Application for Planning Permission for Works or Extension to a Dwelling

Development: Erection of single storey rear extension to create orangery and creation of ensuite on first floor following the demolition of existing outhouse (This application may affect the setting of a listed building)

Location: Hobbs Farmhouse 36 Sea Lane Rustington BN16 2RE

Existing Plans

Existing Elevations

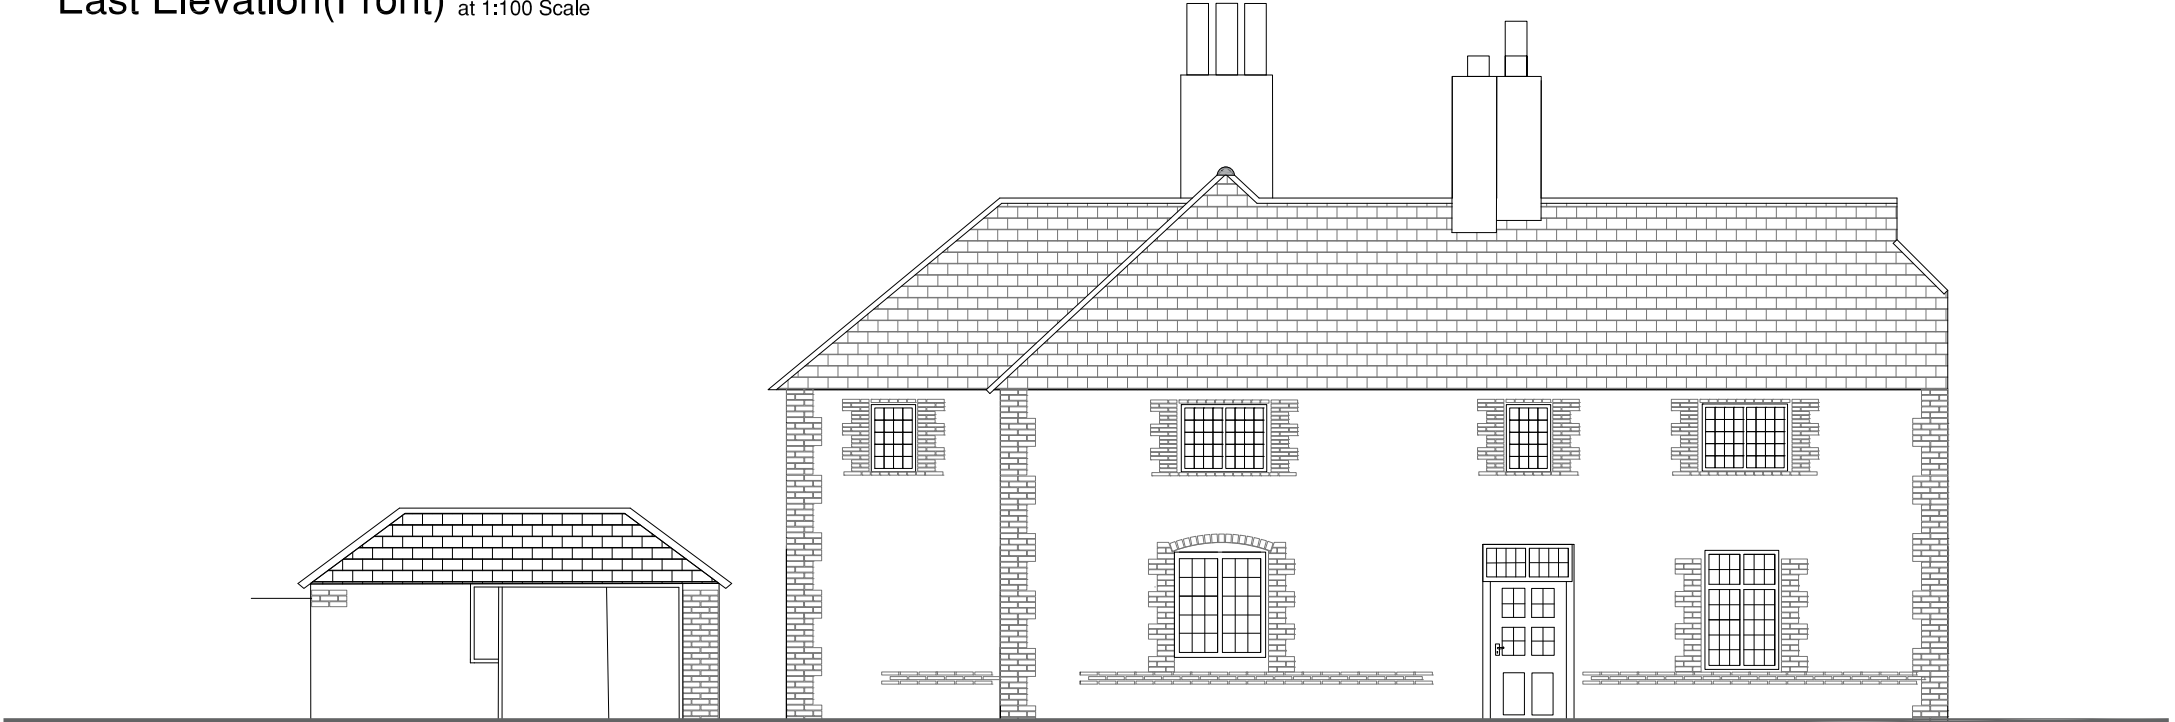
The windows on the existing front and side (south) elevations are inconsistent with the windows on the existing first floor plan. Please review and amend

Drawing: Proposed Elevations

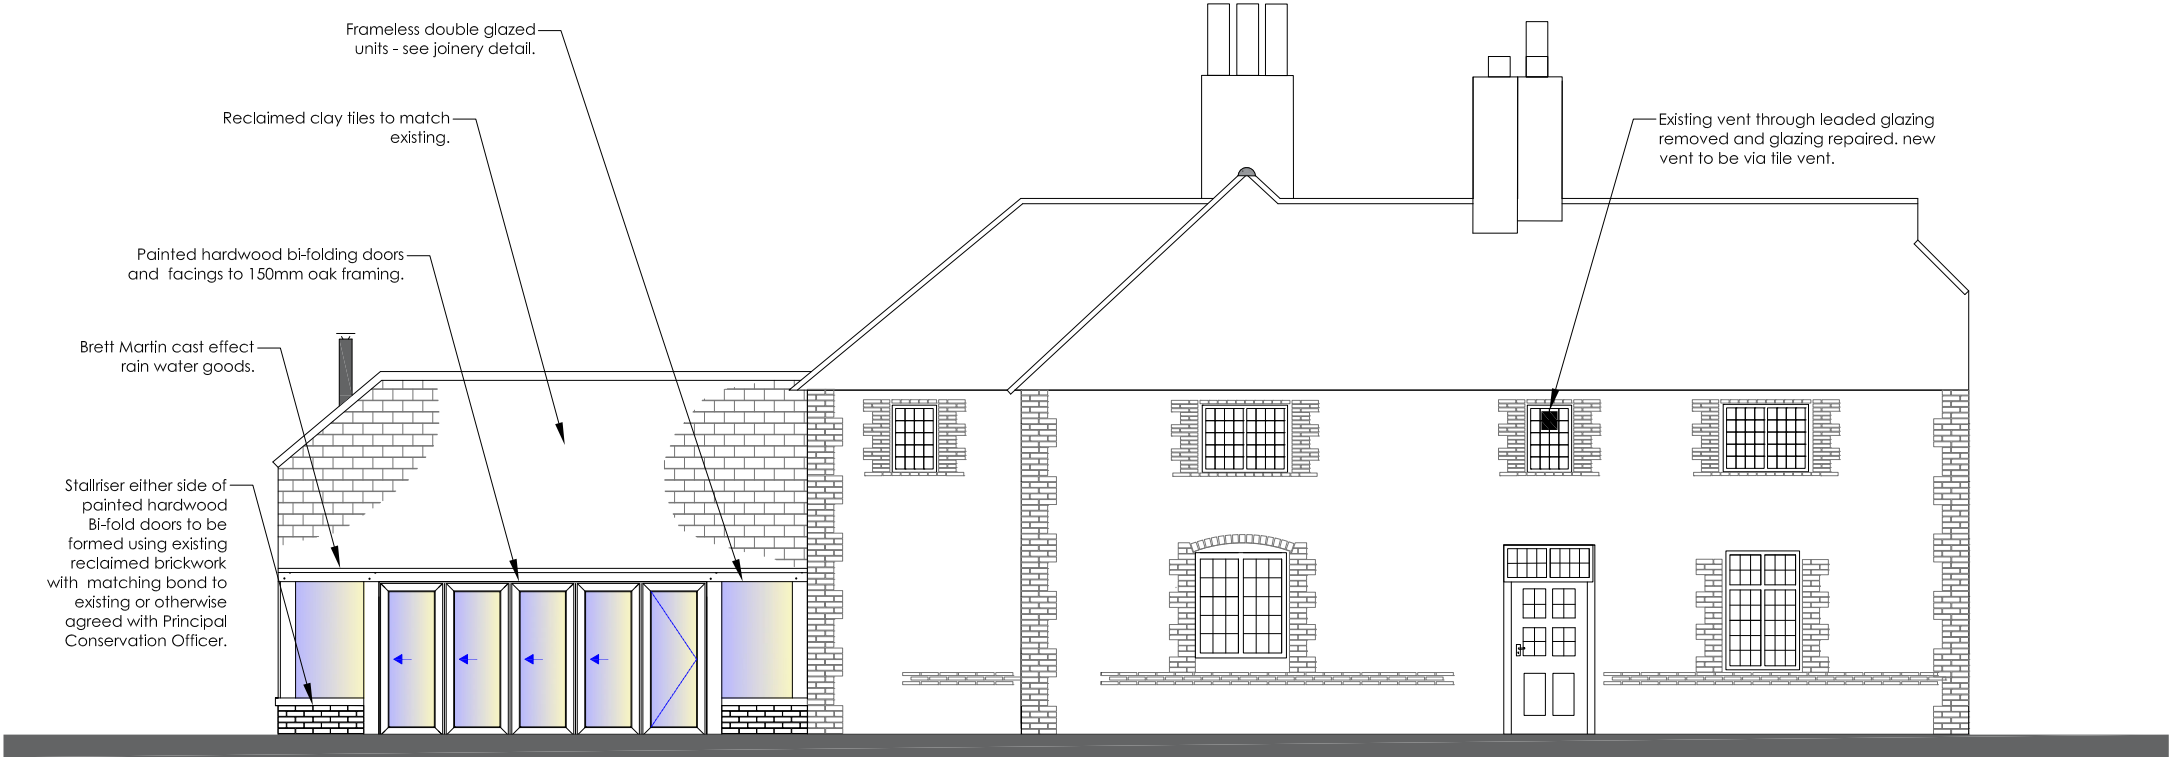
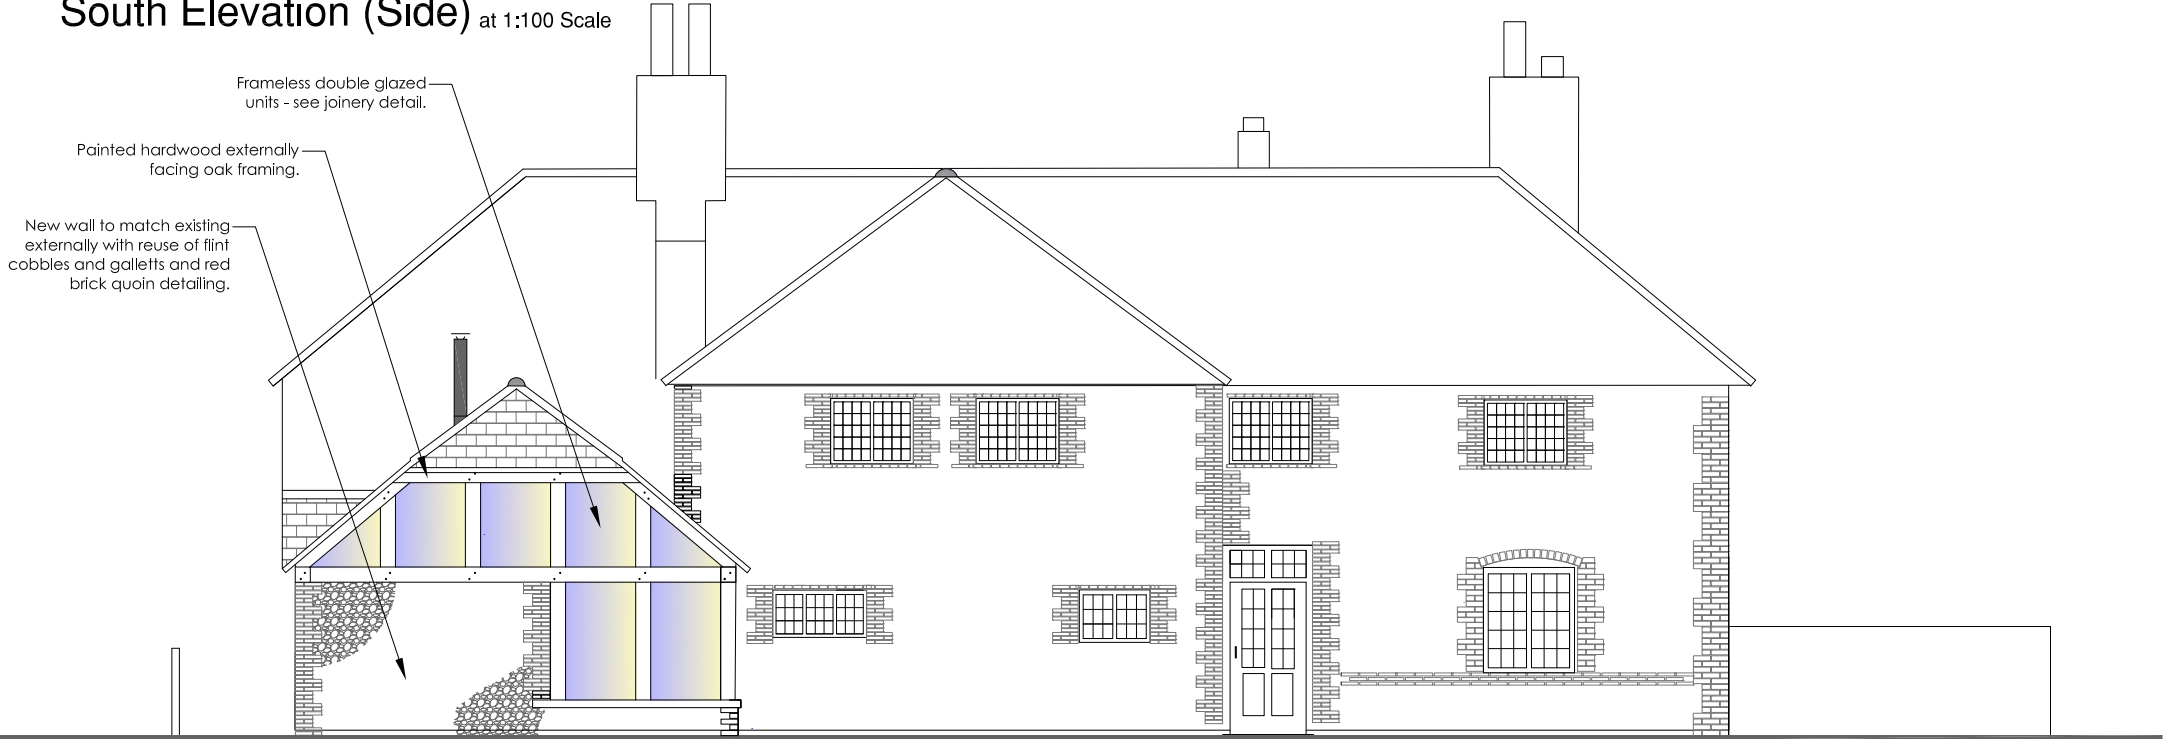
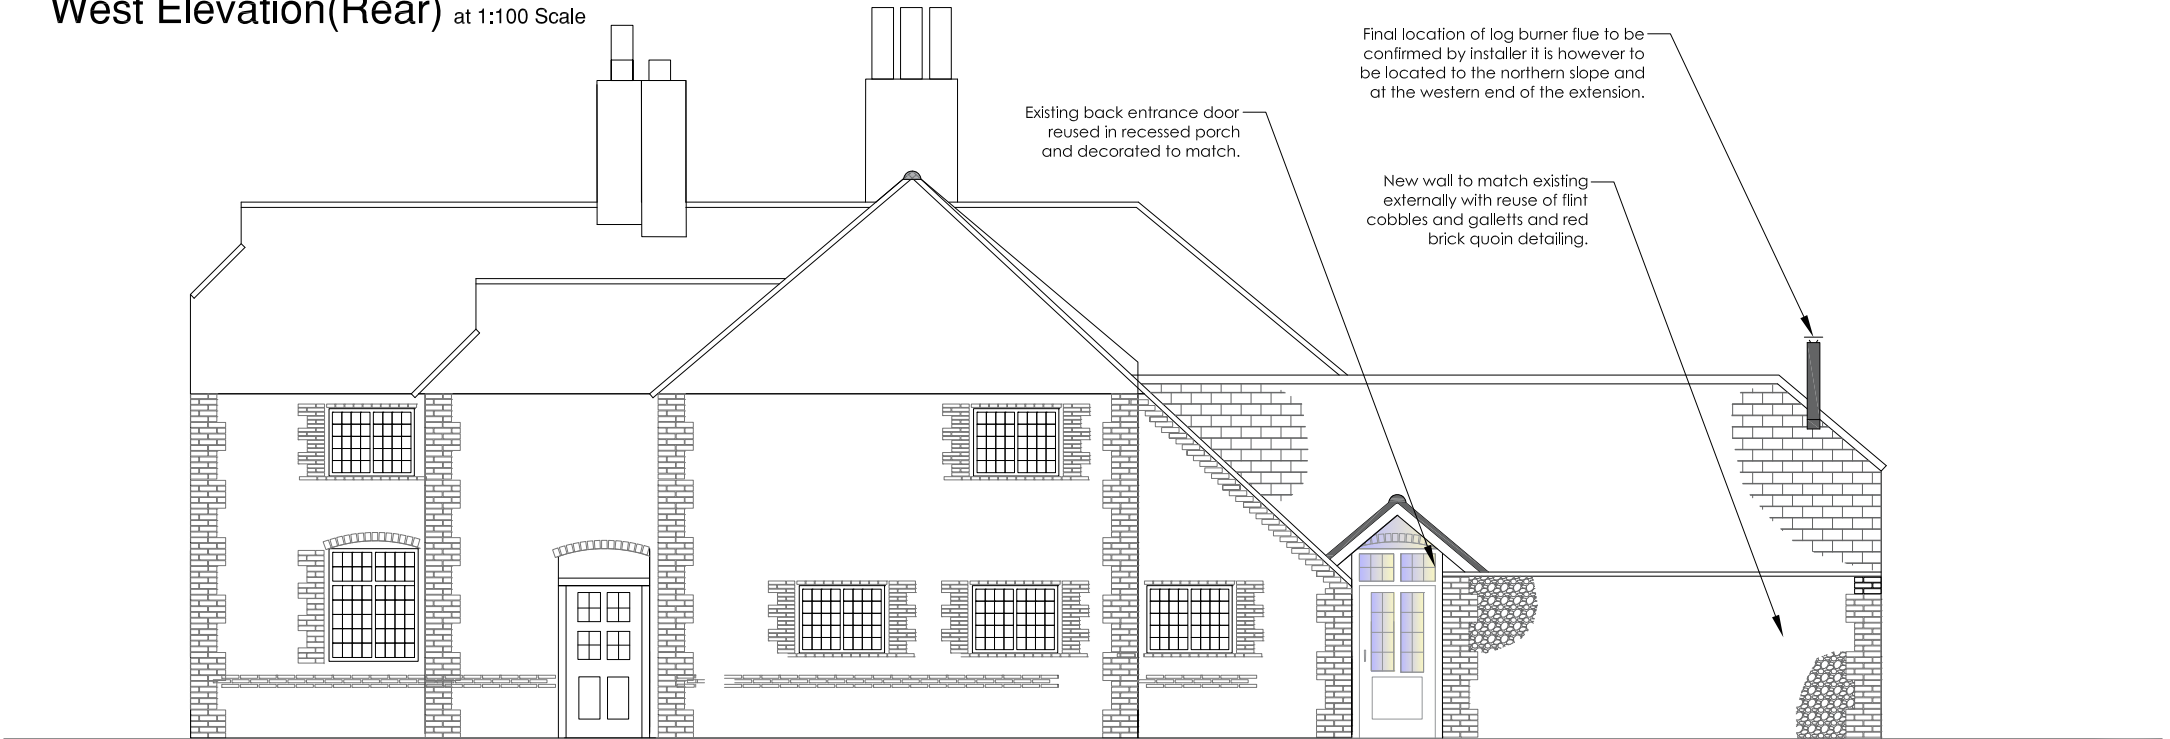
The proposed south (side) elevation is inconsistent with the proposed ground and first floor plan. Please review and amend.
